**WELWYN HATFIELD BOROUGH COUNCIL
EXECUTIVE DIRECTOR - PLANNING, PUBLIC PROTECTION AND GOVERNANCE**

DELEGATED APPLICATION

Application No: 6/2021/3375/HOUSE
Location: 23 Great Braitch Lane Hatfield AL10 9FD
Proposal: Loft conversion including insertion of two rear dormers and three front roof lights
Officer: Ms Elizabeth Mugova

Recommendation: Granted

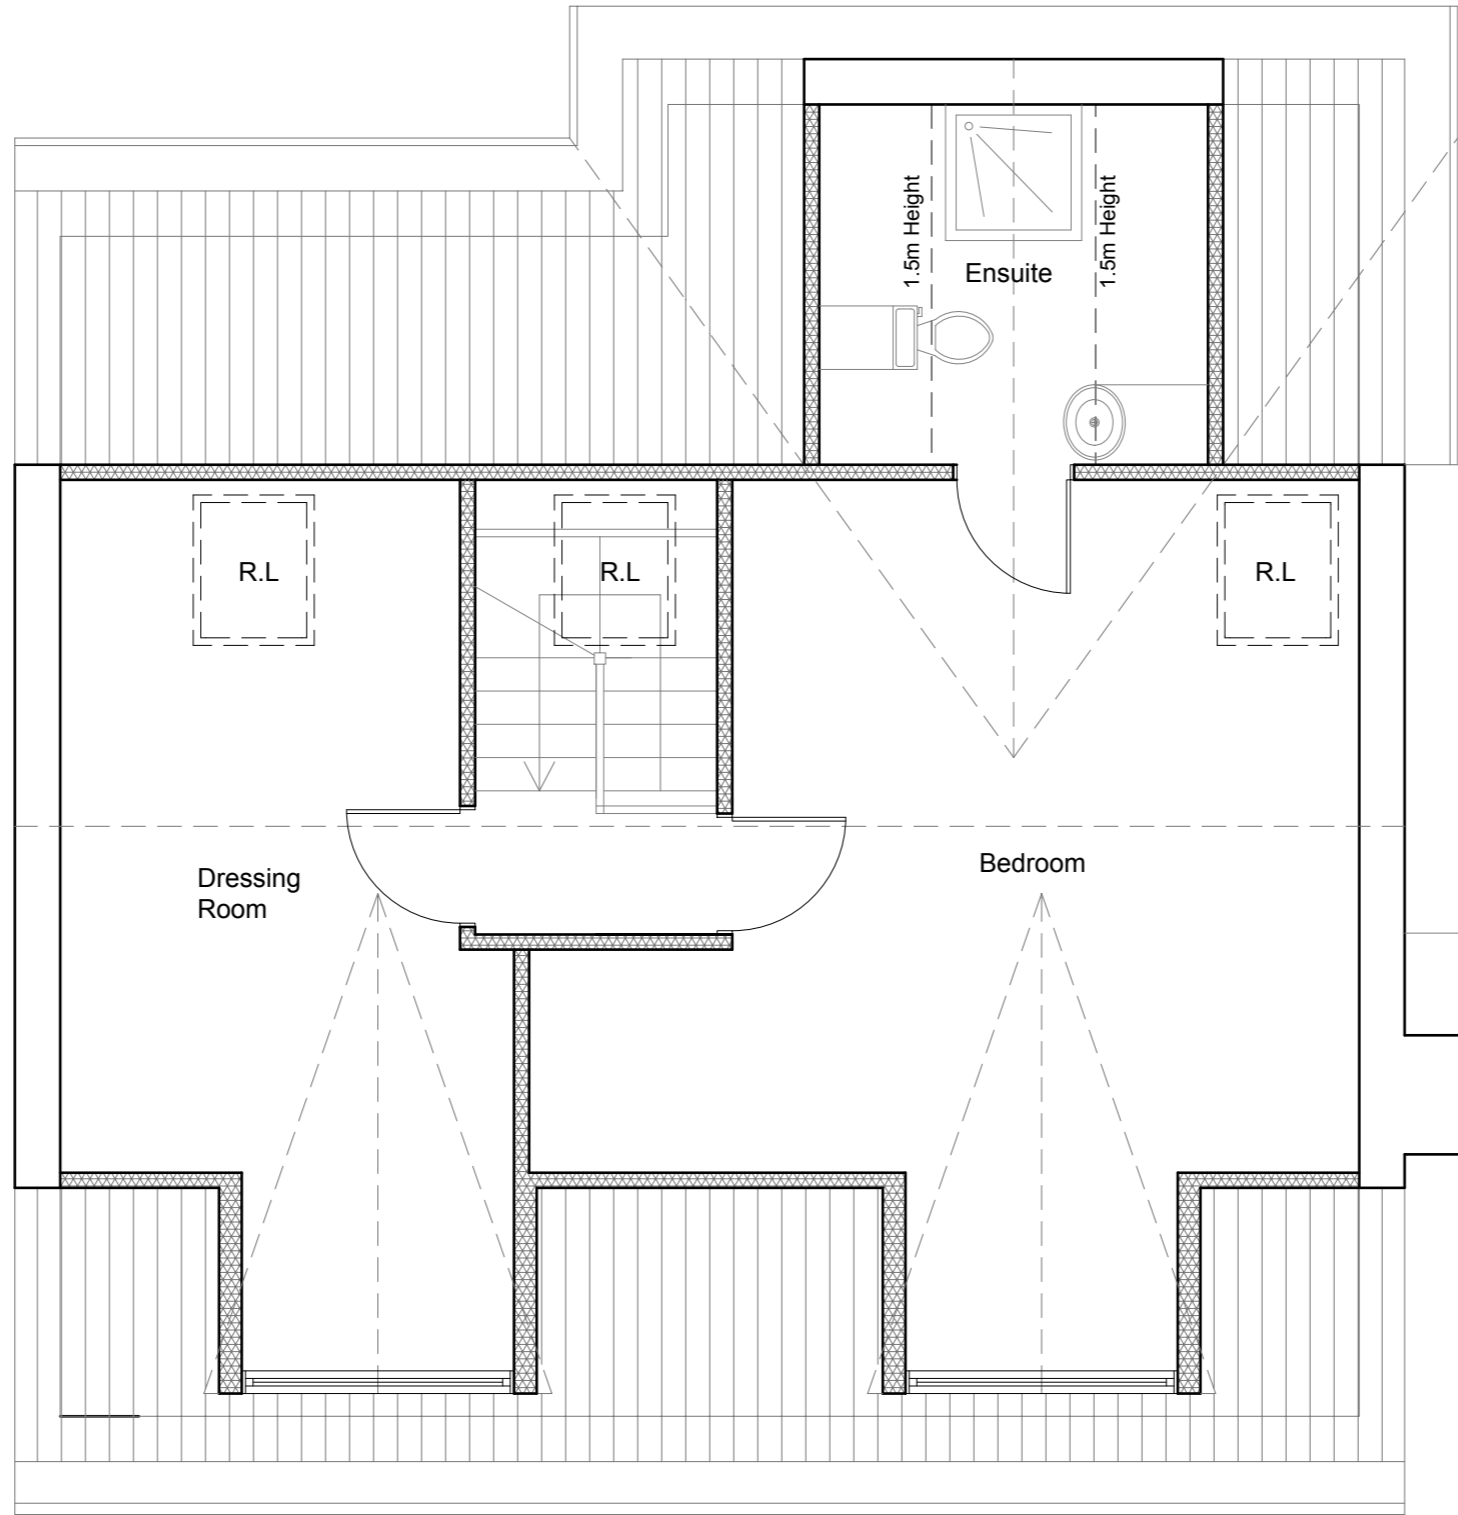
Comment (if applicable): The proposal would increase the amount of bedrooms from four to five. The Council's car parking guidance for a four or more bedroom house in this location is three spaces per dwelling. The application site benefits from a large frontage and a garage which would provide adequate on site car parking provision for the resultant dwelling in line with the Council's SPG. The proposal therefore complies with the Council's access and car parking standards.

Project:	Title:	Scale: 1:100 @ A3
	23 Great Braith Lane Hatfield AL10 9FD	Proposed Elevations	Date: 10 2016
			Drawing No.: 3146 - 05/MT
			Revision
239 Western Road, Southall, Middx, UB2 5HS Tel: 020 8571 1369 info@multicreation.co.uk

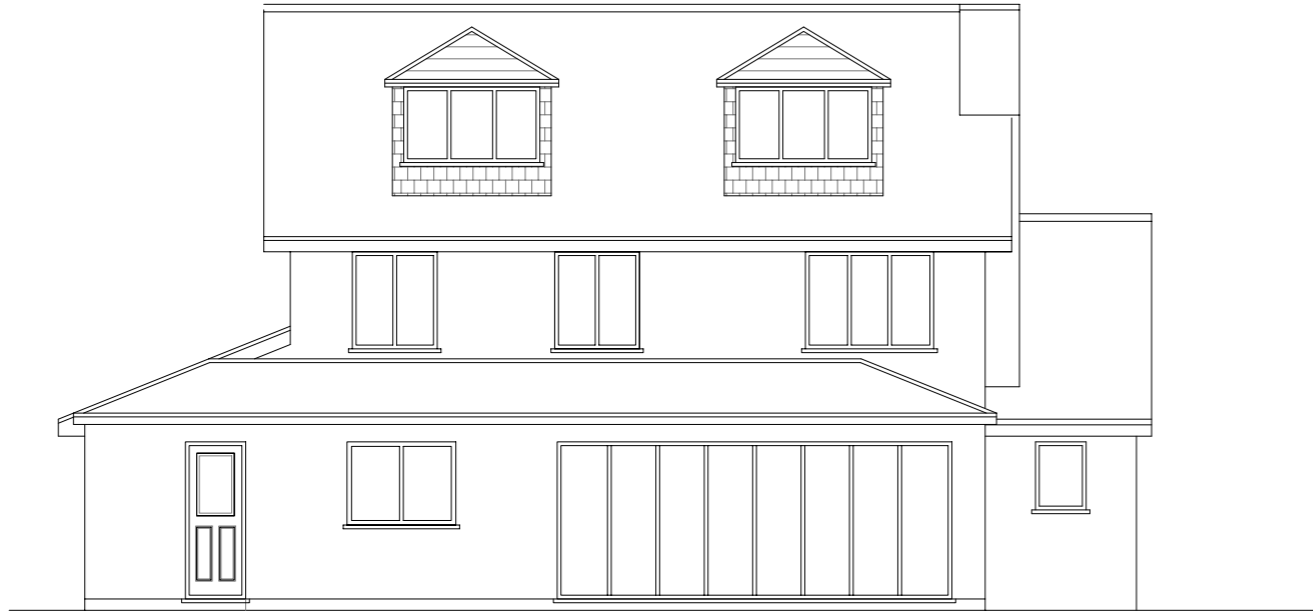
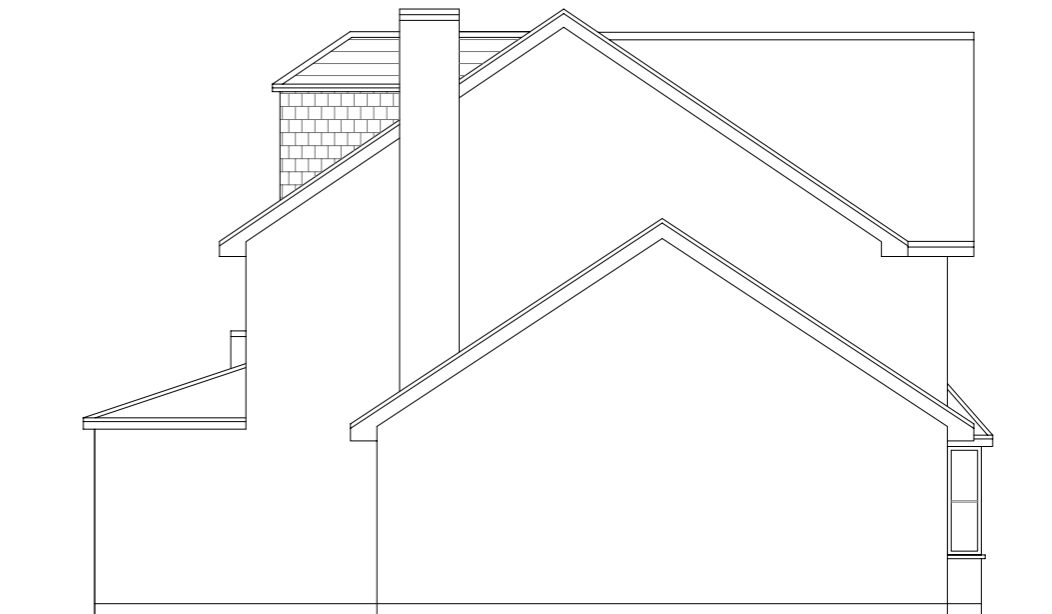
Comment (if applicable):			
Would the development reflect the character of the area?			
<input checked="" type="checkbox"/> Yes <input type="checkbox"/> No			
<p>Comment (if applicable): The proposed rear dormers would be contained within the roof slope, subservient in scale, well separated from the flank elevation and in keeping with existing fenestration.</p> <p>Due to the application site being located on a corner plot the rear dormers would be visible from the east of Great Braitch Lane. However, due to the dormers being subordinate in scale, it is considered that the proposal where would not impact on the street scene along Great Braitch Lane. In terms of the three rooflights proposed to the front elevation, these are considered to respect the size and form of the existing fenestration.</p> <p>The external materials for the proposed development would match the existing house. Subject to a planning condition regarding matching materials, it is considered that the proposal would adequately respect and relate to the existing dwelling and the character of the area in accordance with the National Planning Policy Framework; Policies D1 and D2 of the Welwyn Hatfield District Plan 2005</p>

Hatfield Town Council are concerned that the dormers would be overlooking the neighbouring property at No. 21. All adjoining neighbours were consulted and no representations were received.

Whilst there is potential for overlooking to the side elevation and part of the rear garden of No. 21, the degree of overlooking remains the same as with the existing first floor rear windows. Moreover, No. 21 has a flank obscure-glazed window which faces the rear of the application site therefore, there would be no loss of privacy and limited degree of overlooking to this neighbouring property.

Overall, it is considered the proposal would have no adverse impact on loss of amenities in terms of overlooking or privacy to neighbouring occupiers in accordance with Policies D1 and D2 of Welwyn Hatfield District Plan 2005.
